About the application

Application number: 2021/90247	
What is the application for?:	Erection of dwelling following demolition of existing dwelling (within a Conser
Address of the site or building:	Hirst Clough, 4, Kaffir Road, Edgerton, Huddersfield, HD2 2AN
Postcode:

Type of comment: An objection	
Do you wish your comments to be published on the website anonymously?	Yes
Dear Ms Katie Chew Re: Application No. 2021/62/90247/W 23rd March 2021 We note that the current application is a separate and independent application to that previously approved for the Proposed Extensions at 4 Kaffir Road, Edgerton (Application Ref.: 2020/91143). On that basis, we also include as part of this formal objection, our initial objection letter, within Appendix I of this letter, which needs also to be considered as part of our representation on this matter. We also include within Appendix II, drawings Ref.: 0692/001 & 002, showing as existing and proposed elevations and floor plans. Within Appendix III, we include a series of photographs taken from Lunnclough Hall, showing the partially constructed new build external elevations, up to window head height (under Application 2020/91143). Accordingly, we

Description
PLANS & ELEVATIONS AS PROPOSED

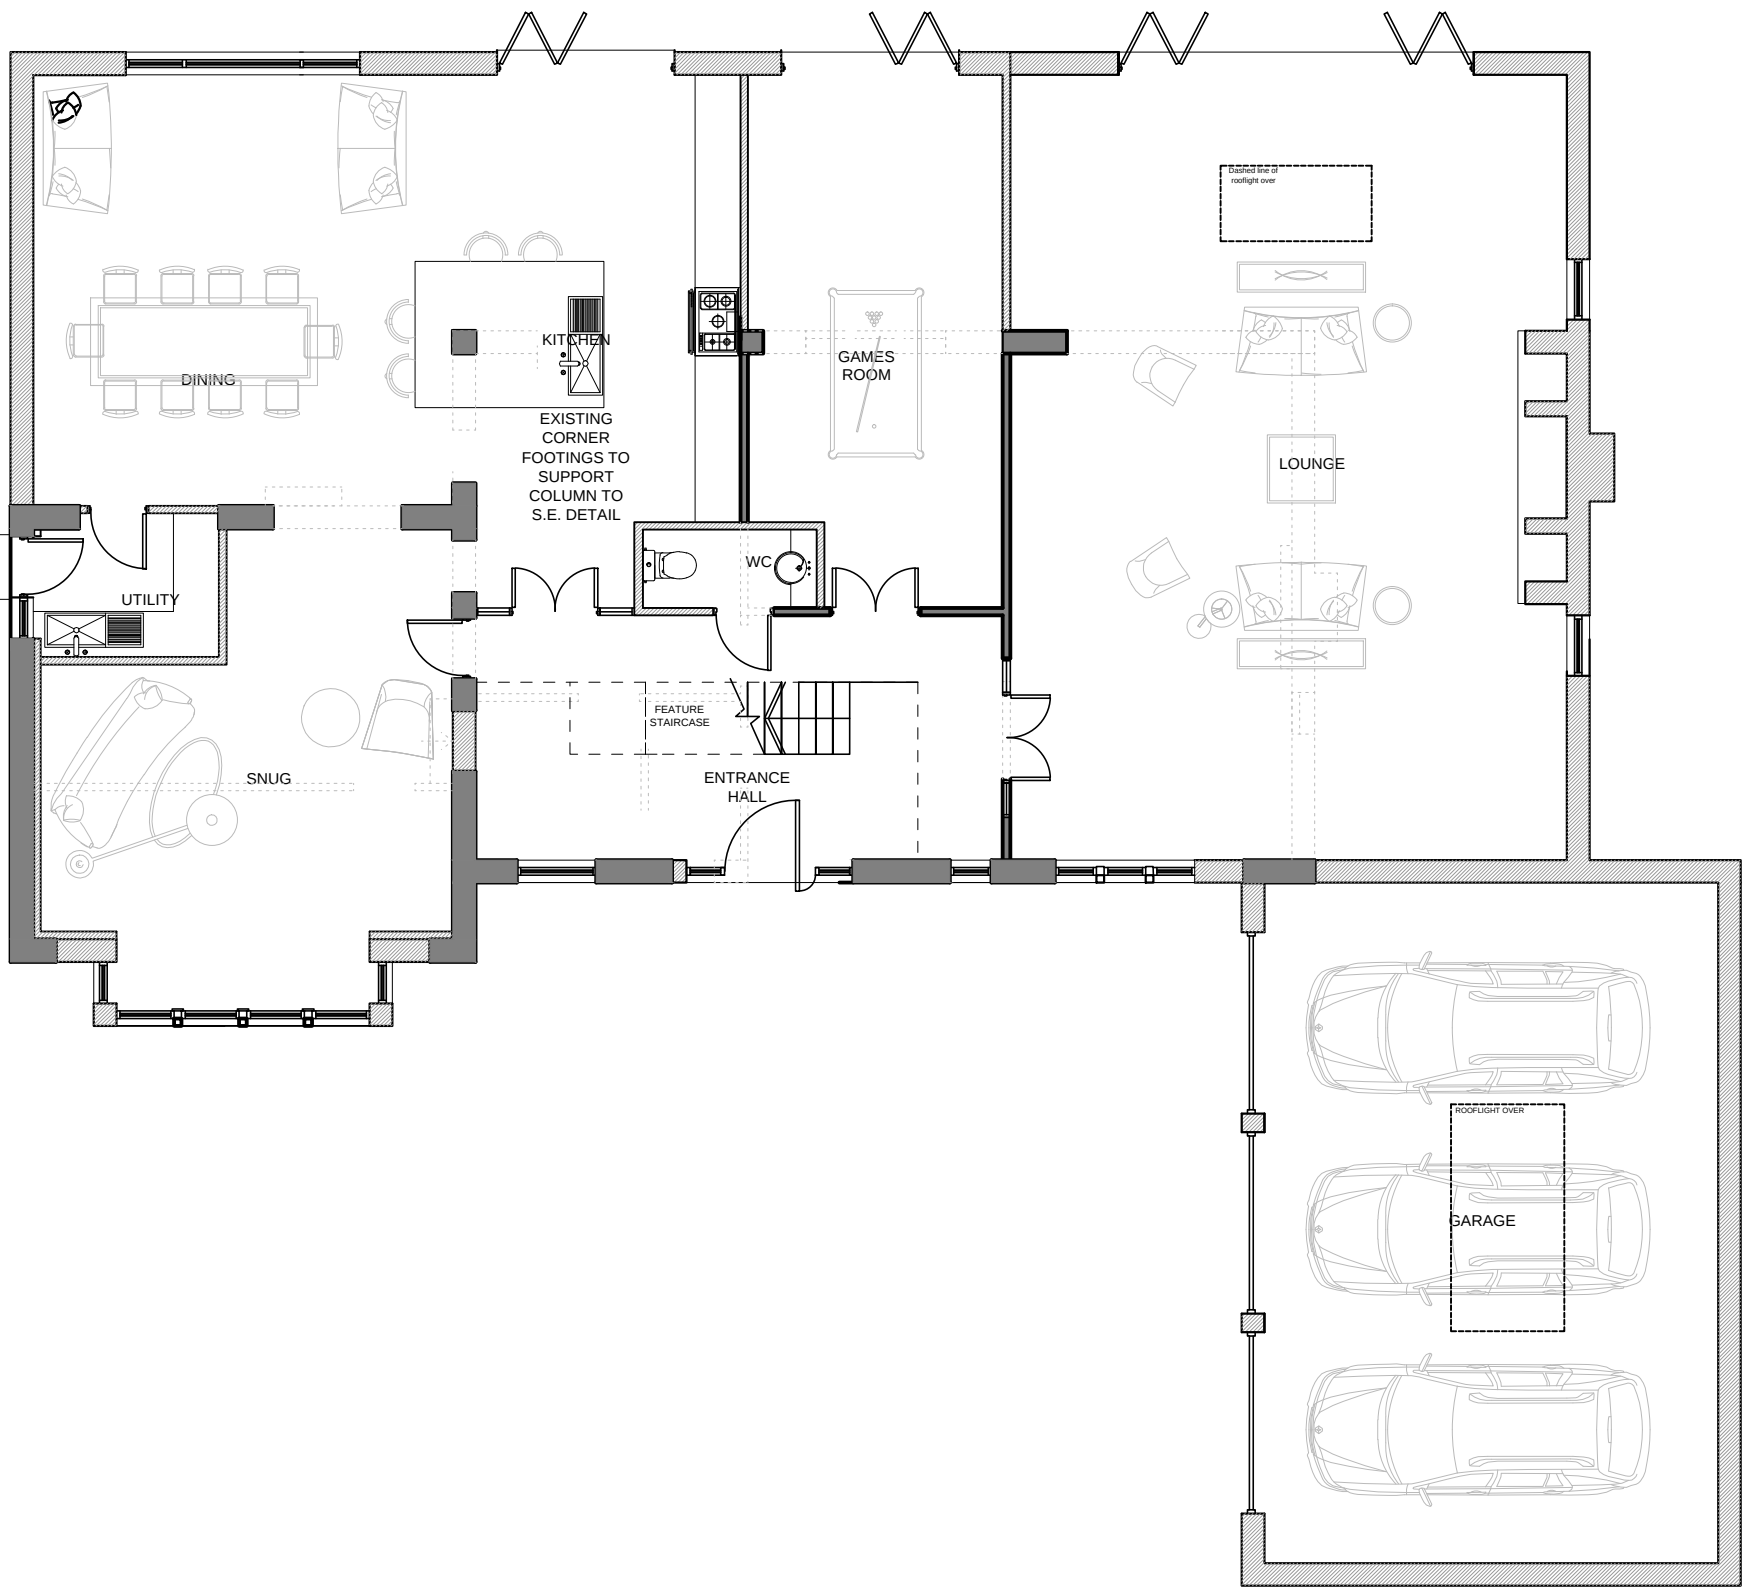
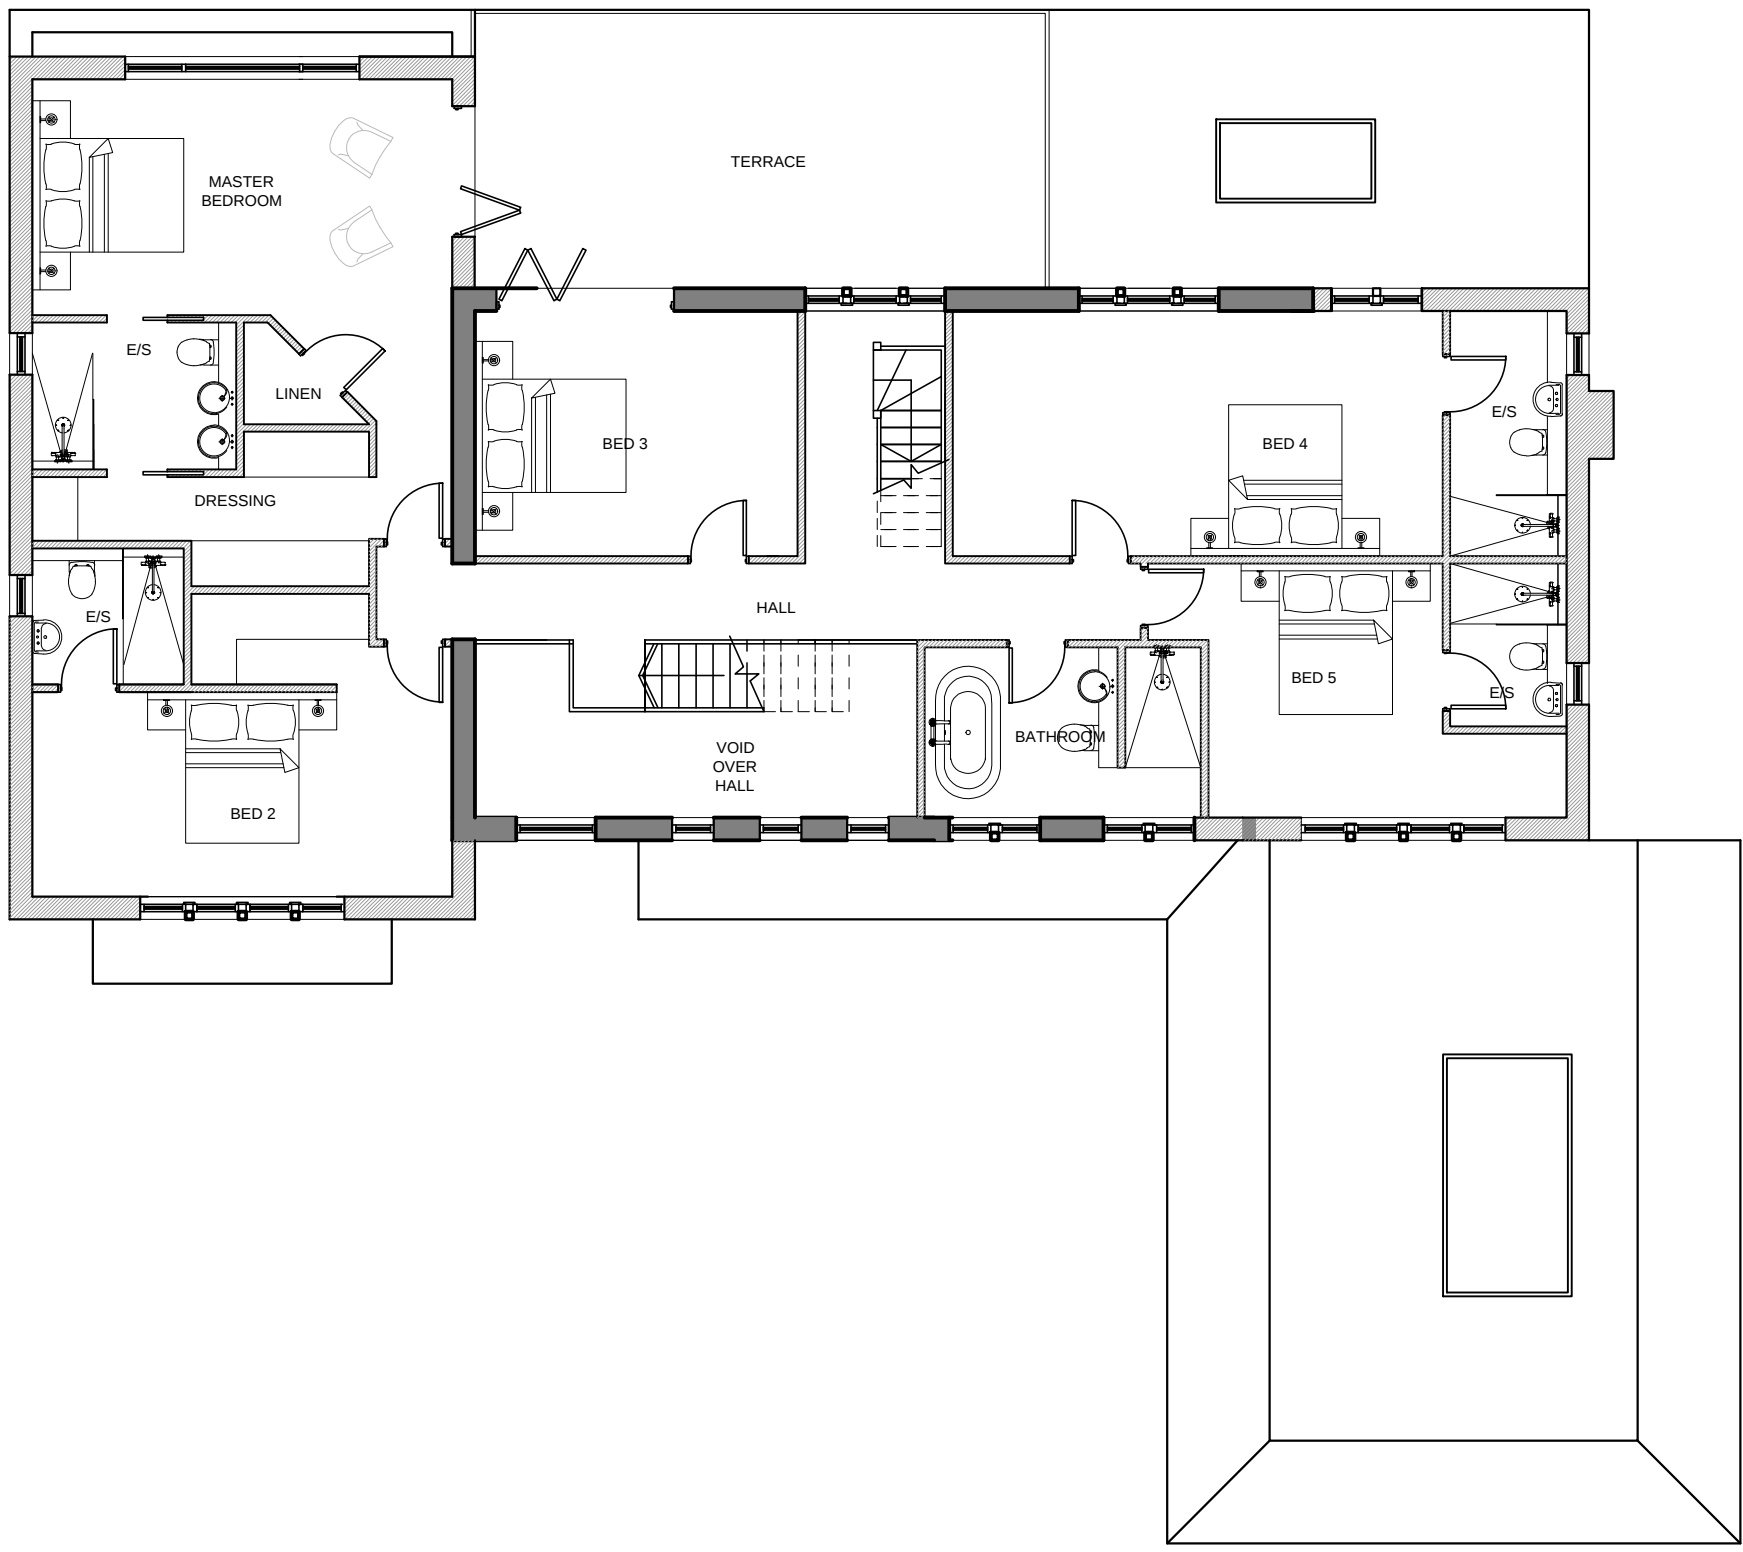
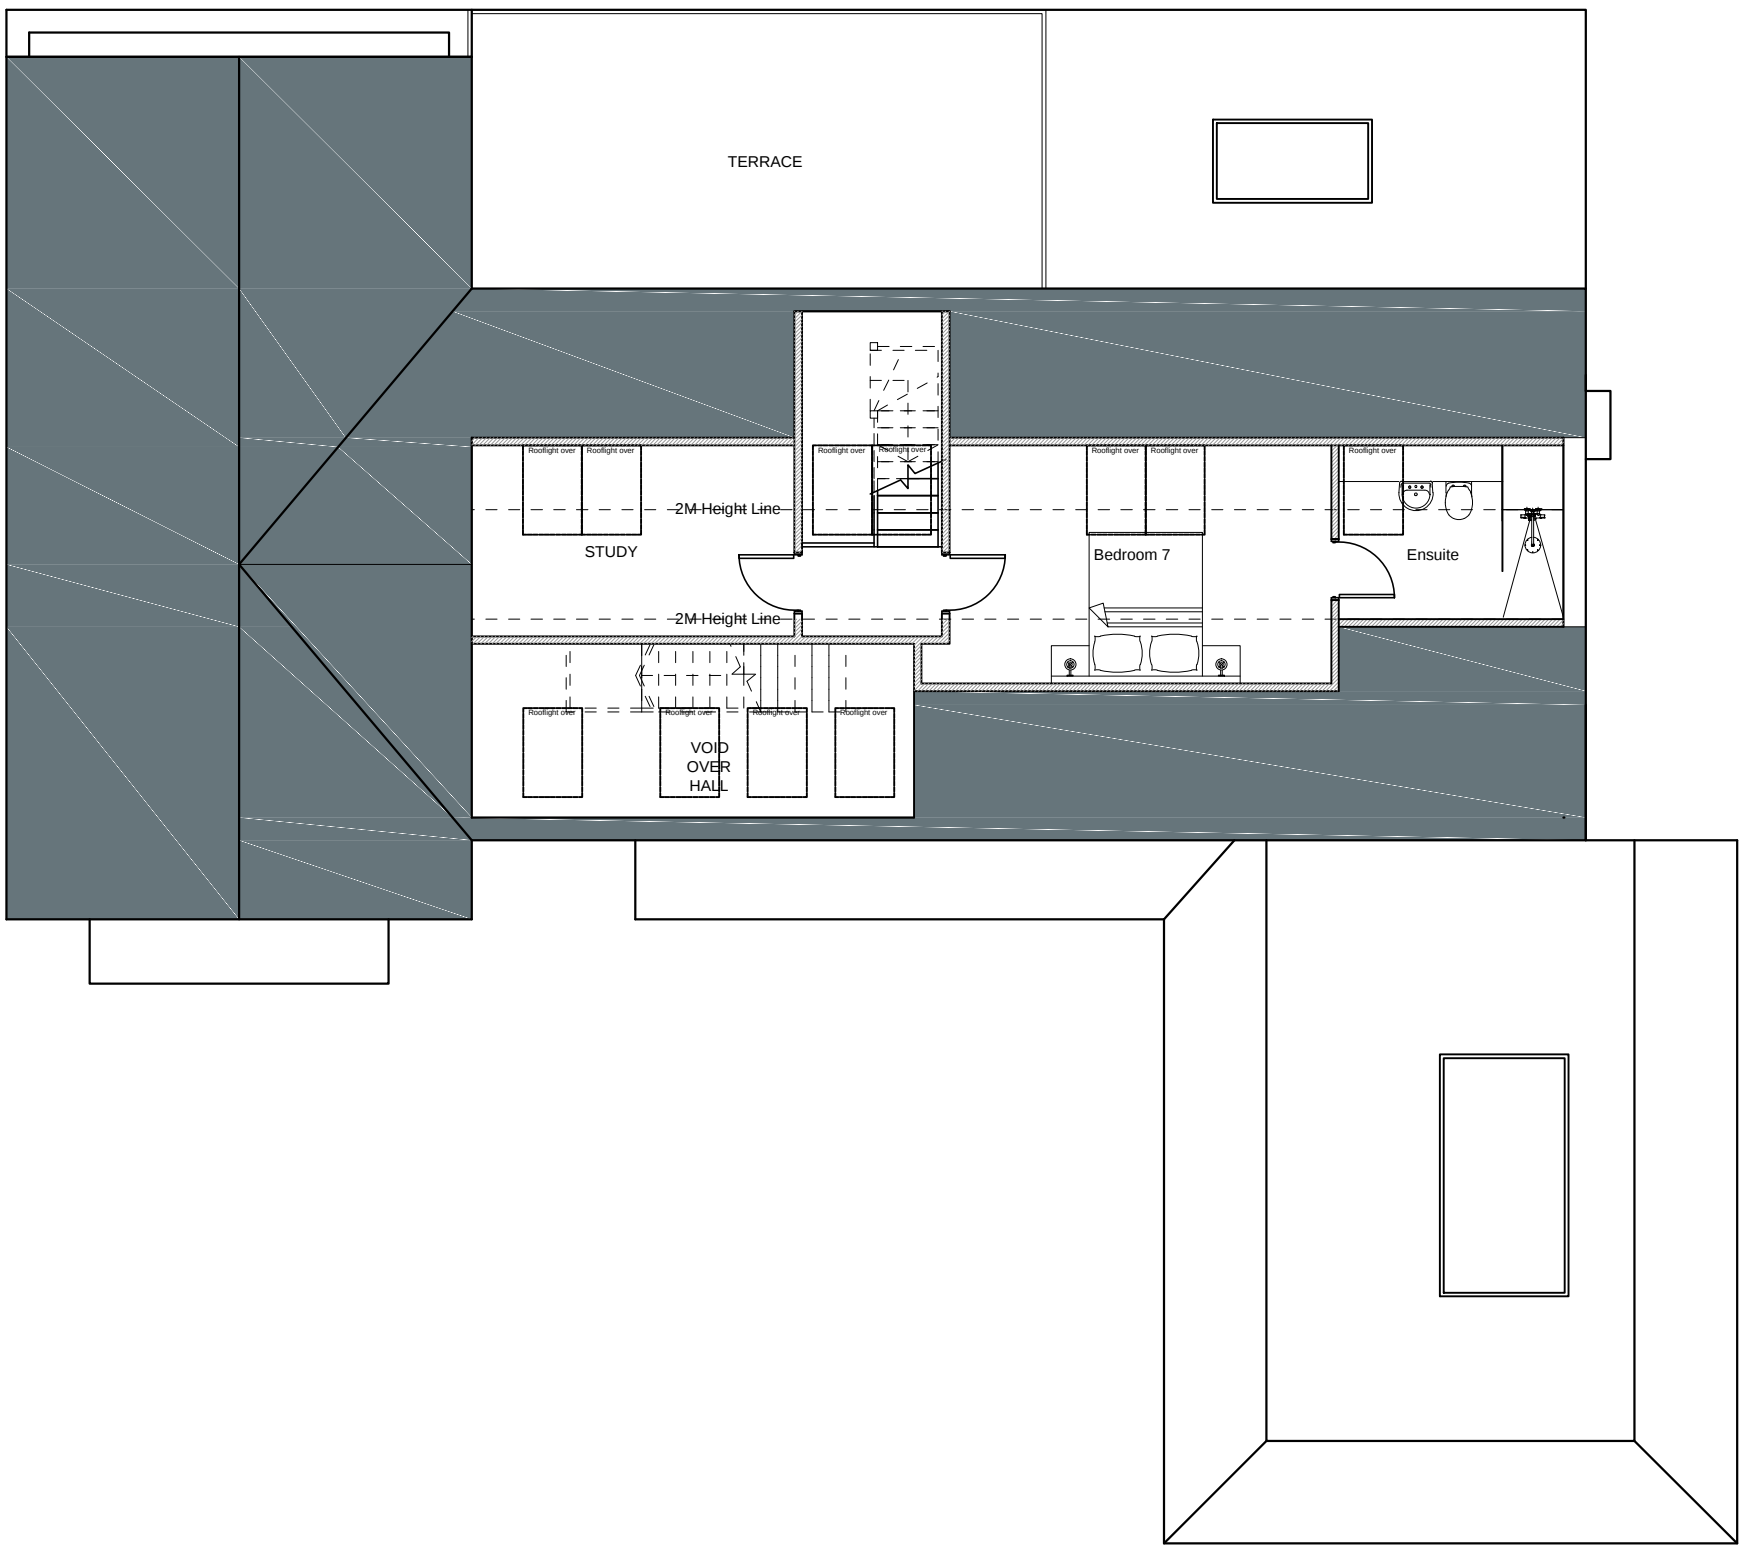
harmonious to the adjacent listed buildings; or the townscape of the wider Edgerton conservation area. The proposed building is both higher and substantially larger in terms of its footprint on the site. The footprint on plan is 316 m² (circa 621 m² taking into account ground, first and second floor areas). The proposed property, including the additional bedroom and en-suite bathroom within the attic/roof space, is in excess of three times larger than the existing house and associated buildings it is to replace (Please see attached photographs taken 21/03/2021 contained within Appendix III). The existing house presently has 36 normal height glazed openings within the various external elevations, along with a small, glazed conservatory at the rear. The proposed development has 72 glazed window openings, of which 36 are double height; considerably more than previous applications in both the front, rear and side elevations. We are also concerned that the re-siting of one of the roof peaks on the front elevation from above the front door detracts from the architectural merit of the design and could have been designed to facilitate a future extension over the triple garage, or later subdivision of the house.

4. From a safety perspective, adding an additional floor to the property will create the opportunity for an additional 54 m² of floor space, and a possible three further bedrooms

within this area. This is in addition to the six proposed bedrooms included at first floor level.

It is not unlikely that the applicant would undertake this increase in bedroom capacity, quite easily without submitting further applications as the additional rooms will be subtle, not

intruding on to the external façade. Our foundation for this opinion is that the initial application drawings included for extending further bedrooms over the garage facility. It is
